STATE OF NORTH CAROLINA
DEPARTMENT OF TRANSPORTATION

Addendum No. 1

RE: Contract ID C203403
WBS # 8CR.10771.20 Etc.
State Funded

1 Section of US-74 EB, 1 Section of NC-177 and 8 Sections
Of Secondary Roads

DETAIL FOR MAP #2

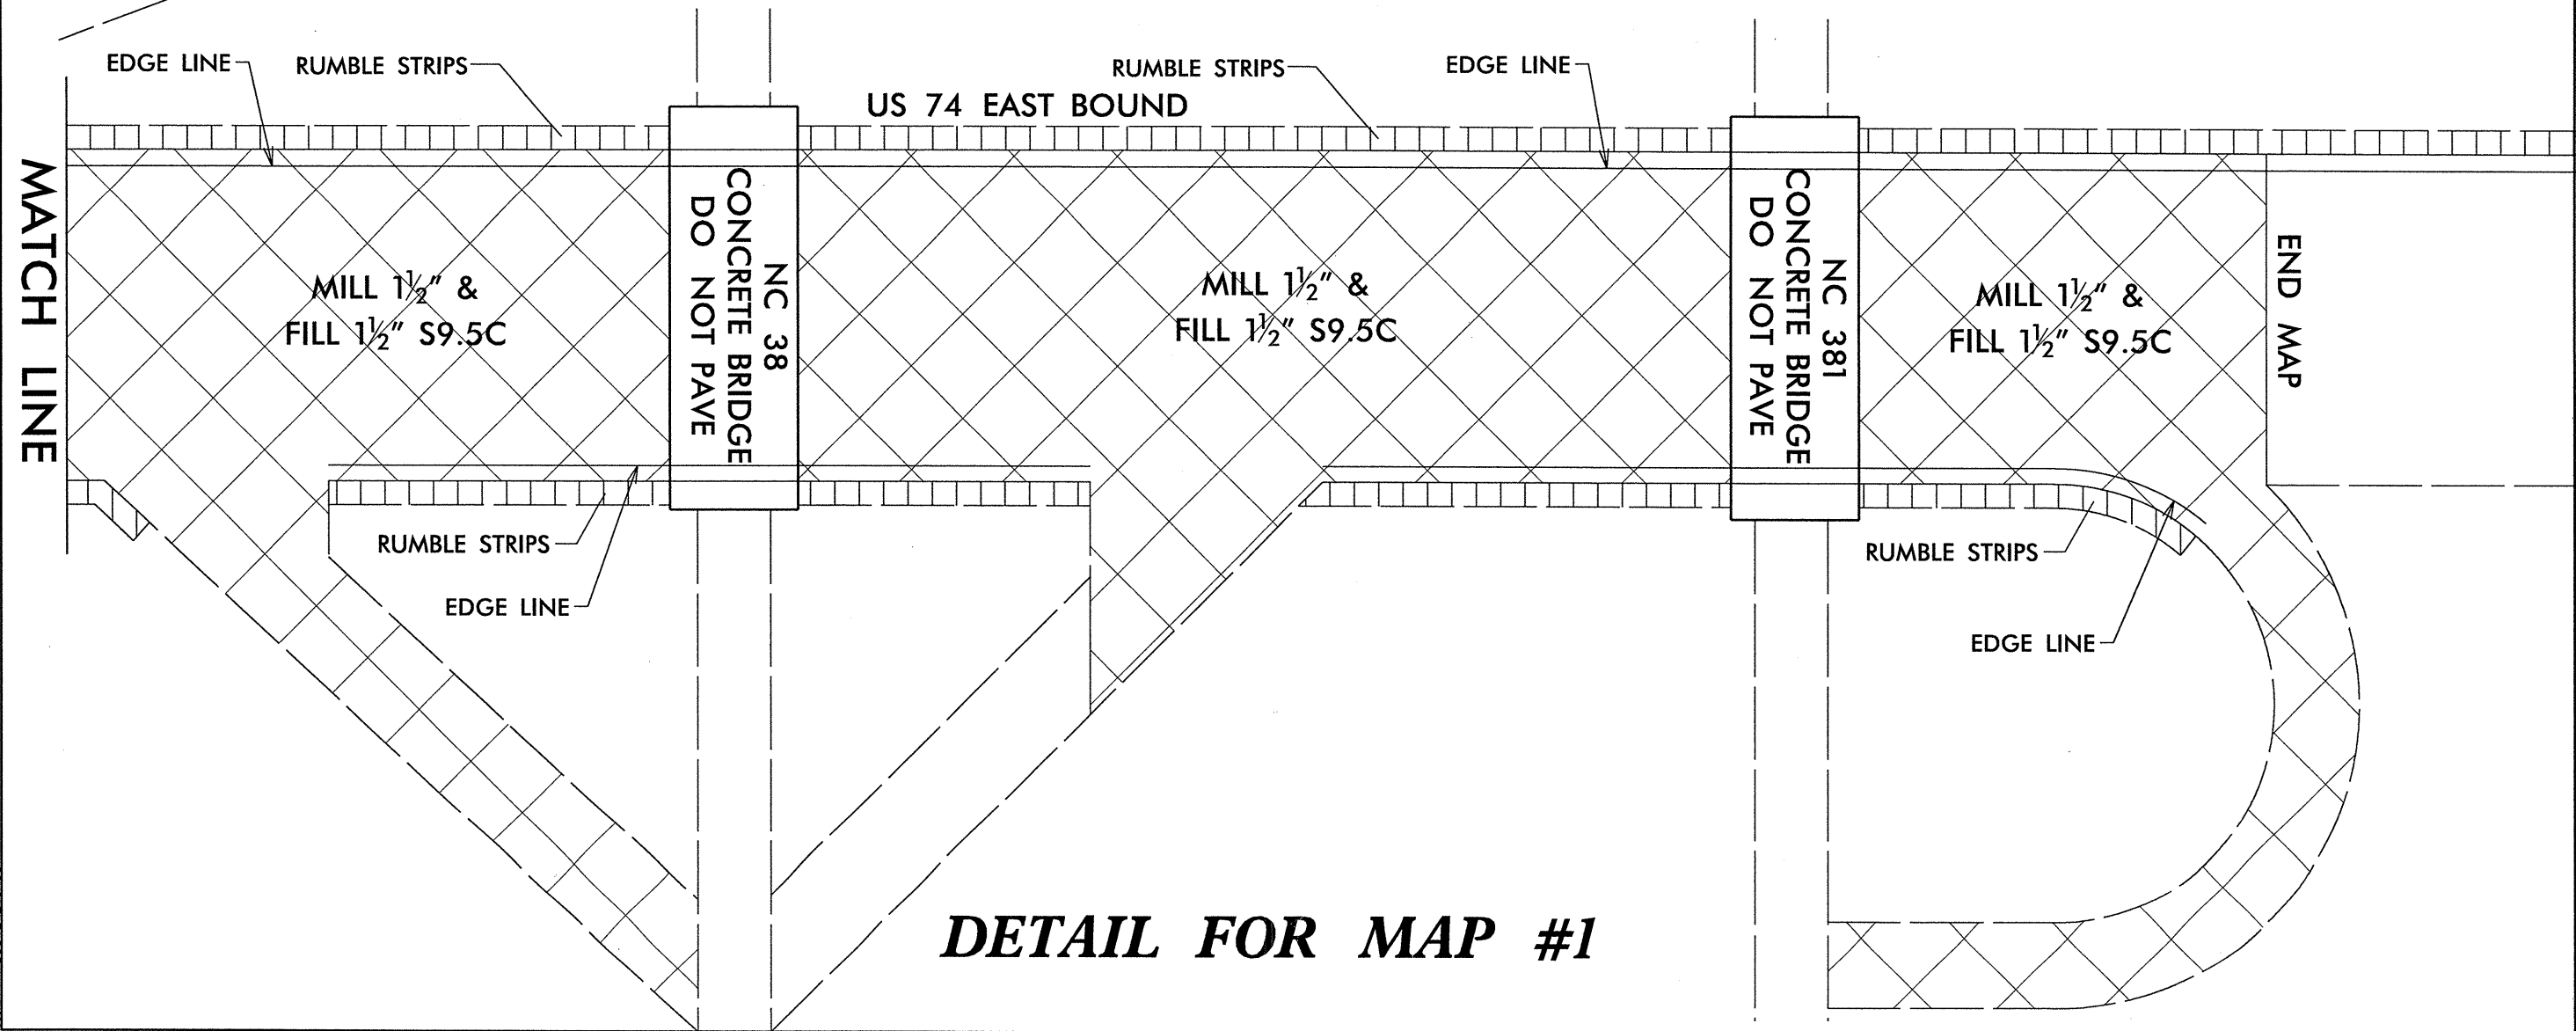
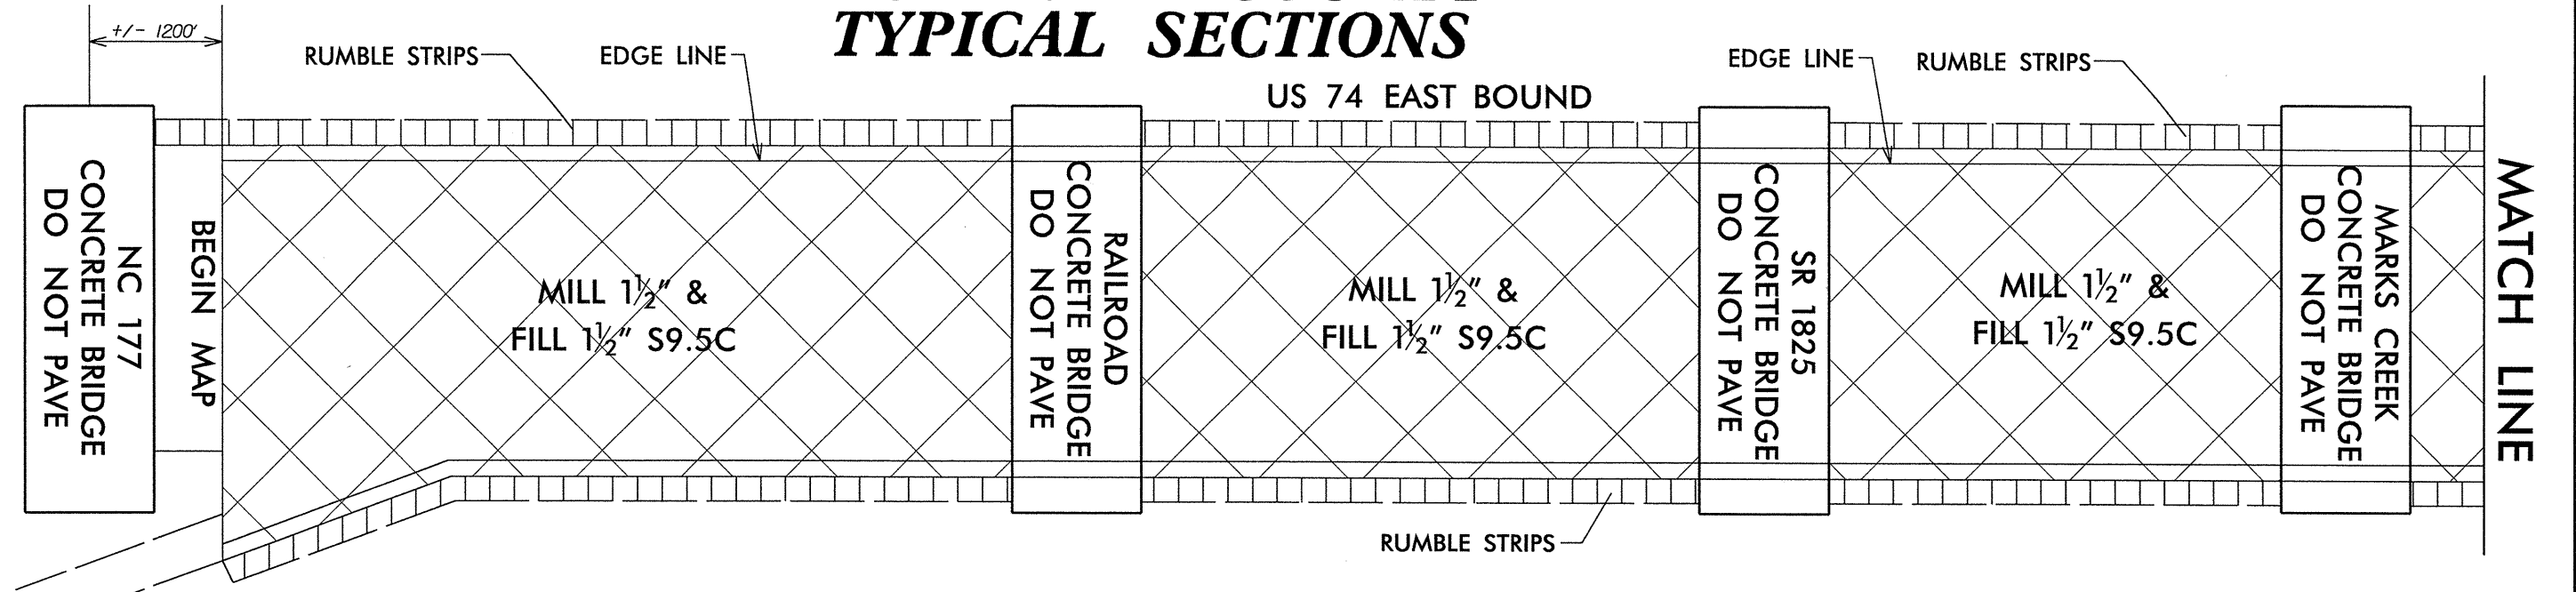
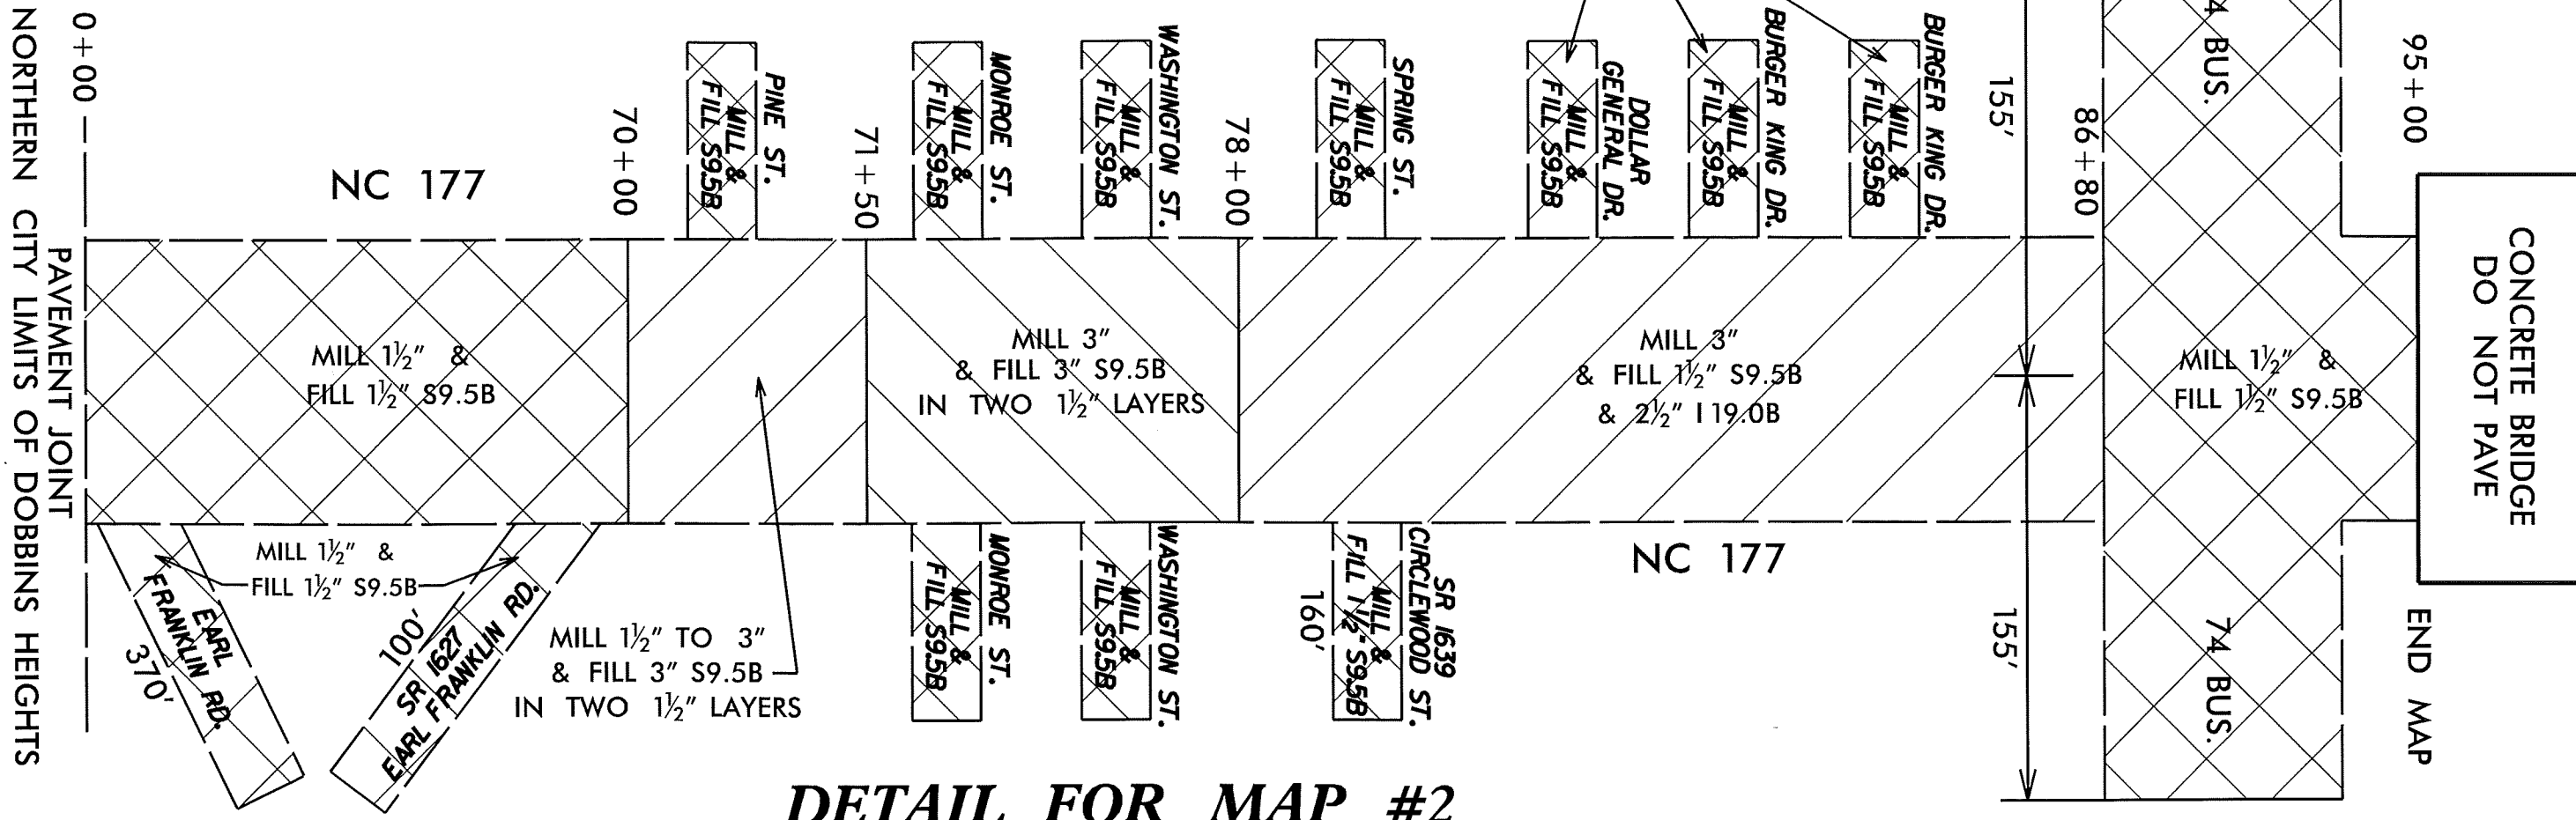
On Sheet No. 6 a note has been added to the "Detail For Map #2" to describe the work to be performed at "Burger King Drive" and "Dollar General Drive". Please void Sheet No. 6 in your plans and staple the revised Sheet No. 6 thereto.
